**WELWYN HATFIELD BOROUGH COUNCIL  
EXECUTIVE DIRECTOR - PLANNING, PUBLIC PROTECTION AND GOVERNANCE**

**DELEGATED APPLICATION**

**Application No:** 6/2020/1702/HOUSE  
**Location:** 3 Buttercup Close Hatfield AL10 9FH  
**Proposal:** Erection of single storey rear extensions following demolition of existing conservatory; garage conversion and first floor extension over existing garage  
**Officer:** Mr Tom Gabriel

drawing
**FLOOR AND ROOF PLANS
AS PROPOSED**

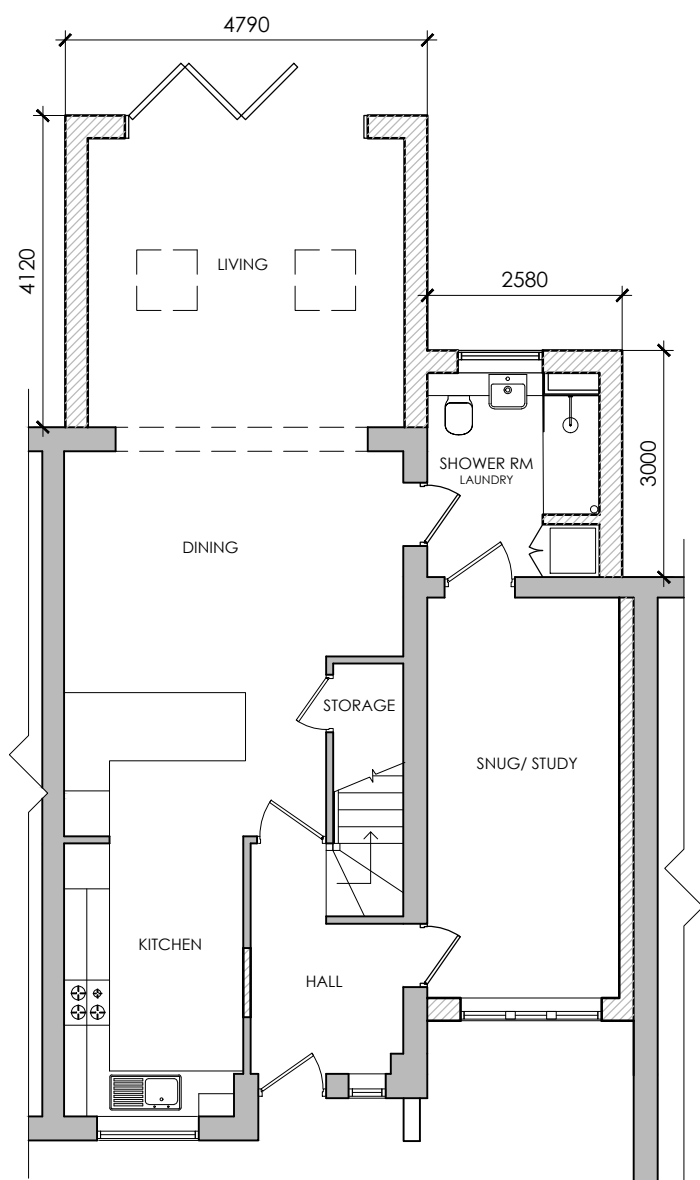
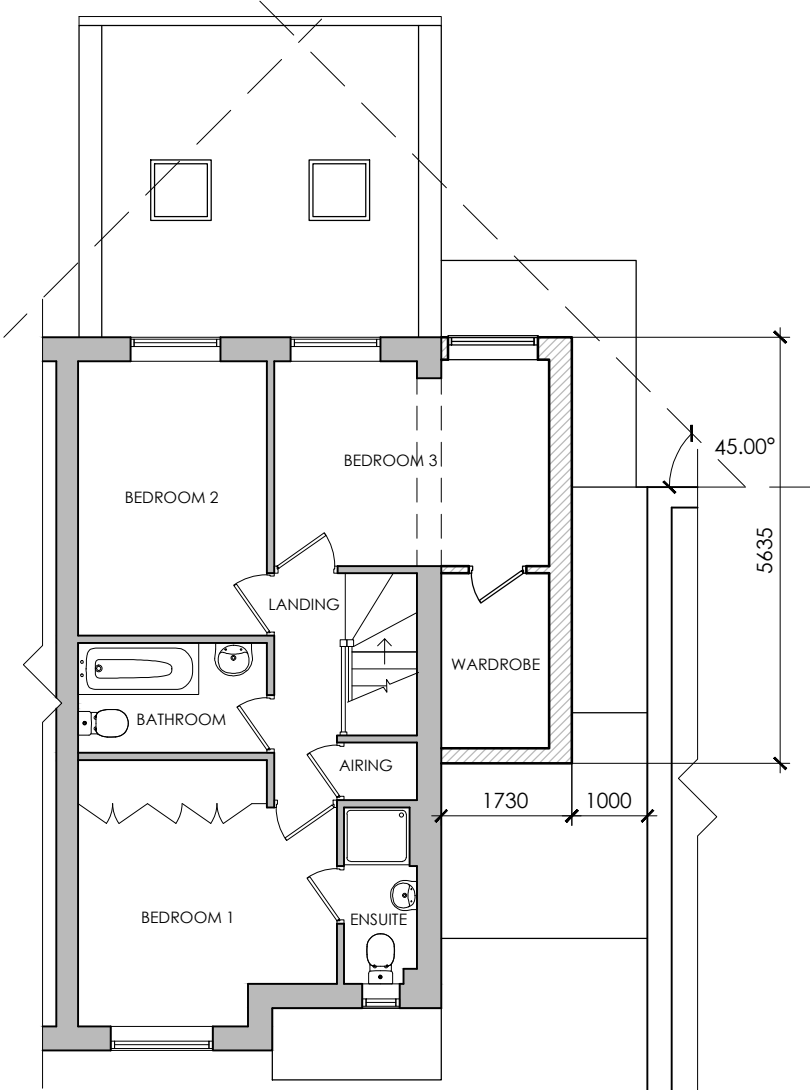
The proposal would result in the loss of a garage parking space, it is notable that the size of the garage falls below the minimum dimensions set out in Interim Policy for car parking and garage sizes. Whilst the additional room is labelled as a snug/study, it could be used as a bedroom and an increase in the number of bedrooms from three to four. The Council's parking guidance SPG recommends that in this area 2.25 spaces are provided for a 3-bed dwelling and 3 spaces should be provided for a 4-bed dwelling.

drawing  
**ELEVATIONS  
 AS PROPOSED**

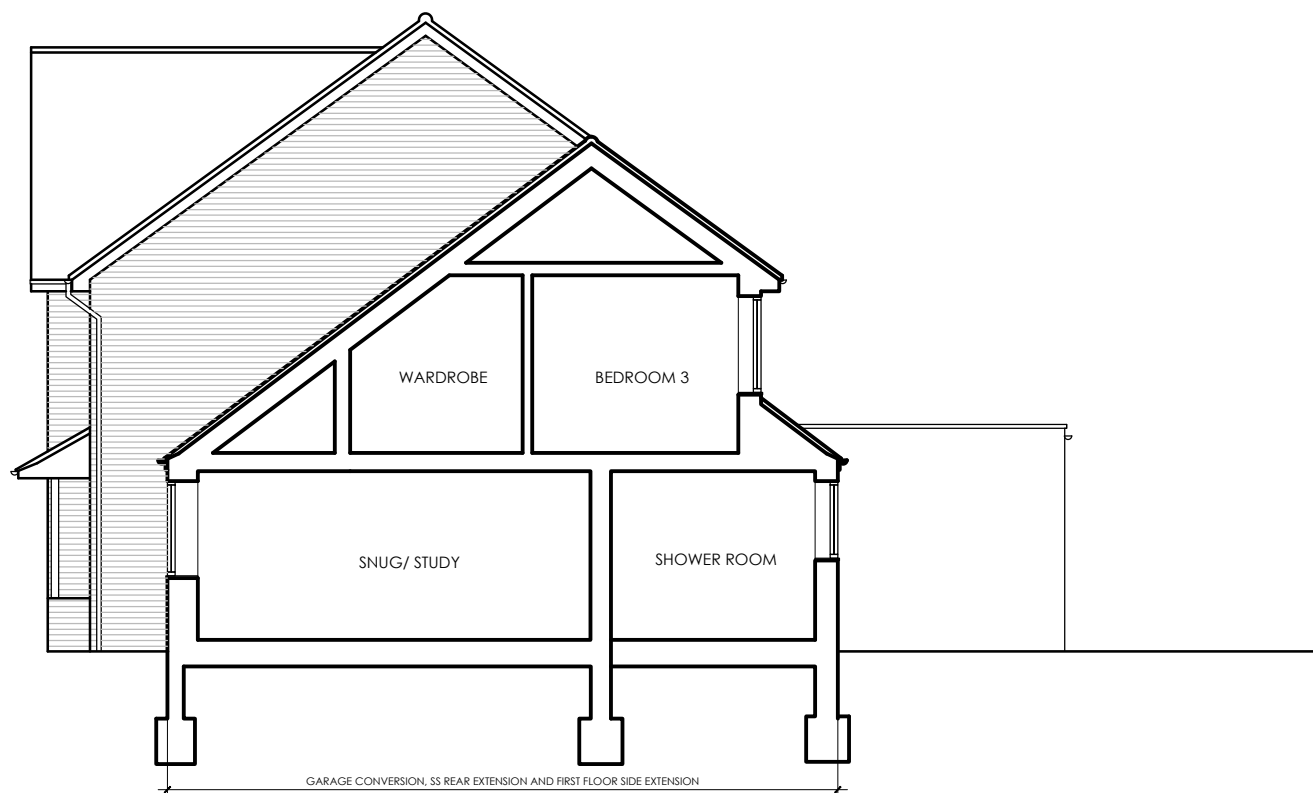
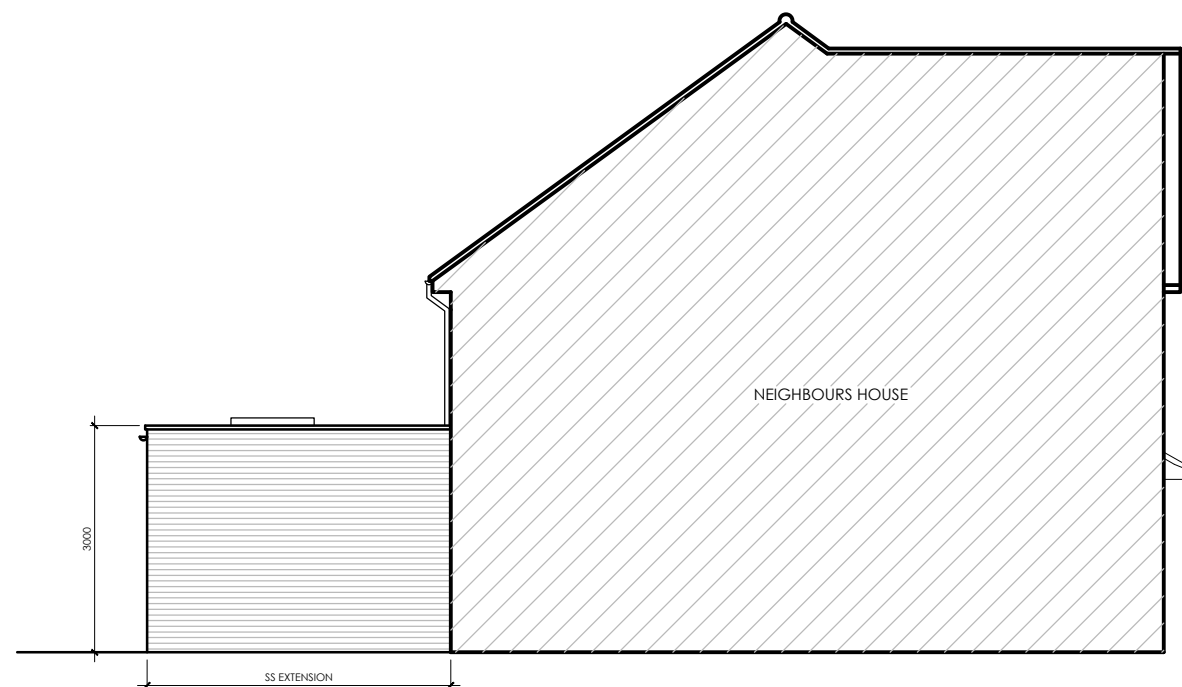
**Comment** (if applicable): The rear extension would be 3m high on the boundary with both neighbours. It would extend to the rear of the dwelling at 1 Buttercup Close by 4.12m and would have an acceptable impact upon this dwelling. Sited to the north of the dwelling at 1, it would not result in a significant or harmful degree of overshadowing for that dwelling.

The ground floor element of the rear extension would extend 3m beyond the rear wall of the neighbouring dwelling at 69 Campion Road, the first floor element by 2m (it would be set off the boundary with 69 by one metre). It is considered that this relationship between 69 and the extended dwelling at 3 Butterfly Close is such that the rear extension there would have an acceptable impact upon the amenities of 69 Campion Road and would not appear overbearing or visually intrusive when viewed from the ground floor windows at the rear of that dwelling, or result in a harmful loss of light for that property. While the rear garden of 69 is relatively small and enclosed to the rear by the flank gable wall of a garage, the extension would not result in a significant or detrimental degree of enclosure or overshadowing of the rear garden of 69.

The impact of the first floor side extension for the flank window at 69 Campion Road facing the application site would be acceptable as this appears to be a secondary window.

In terms of the use of the garage as another room, this would not harm privacy as there would only be a window in its front elevation which would not cause overlooking or loss of privacy for the neighbouring properties. Any noise which may arise from the use of the garage as a room may be addressed through noise insulation under the Building Regulations.

drawing  
**SITE PLAN & SECTION  
 AS PROPOSED**

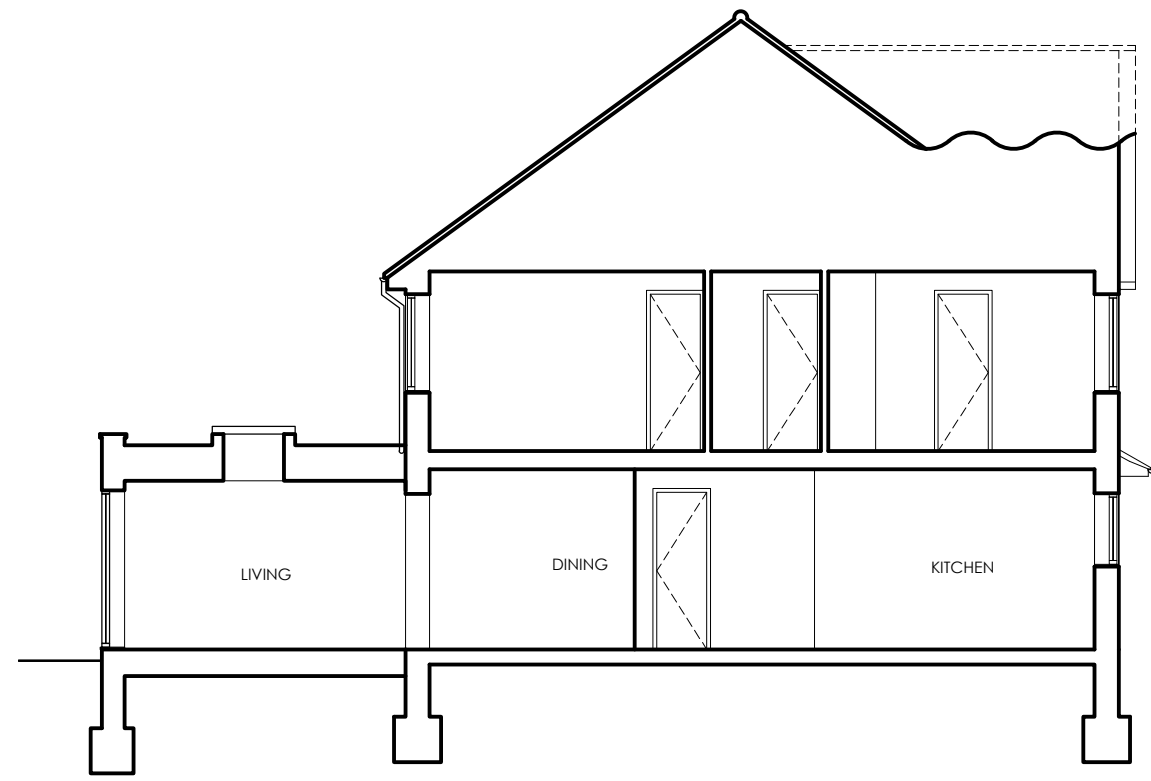
In terms of the neighbour's comments, it is not clear how the proposed changes to the driveway would affect the neighbour's garden as the part of the driveway adjacent to that garden is already laid as hardstanding.

The submitted plans show three parking spaces can be provided within the red line of the application site should additional parking be required. Whilst it appears that some of the land required for two of the parking spaces lies within the communal access/ turning area, the applicant has signed

Certificate of Ownership A confirming that there are no other owners of any part of the land to which the application relates. On the basis of the information submitted, it is concluded that adequate on-site parking can be provided. Should planning permission be granted, it would be reasonable to impose a condition requiring the parking spaces to be laid out and made available prior to occupation of the extended dwelling. An informative is also suggested in respect of land ownership.
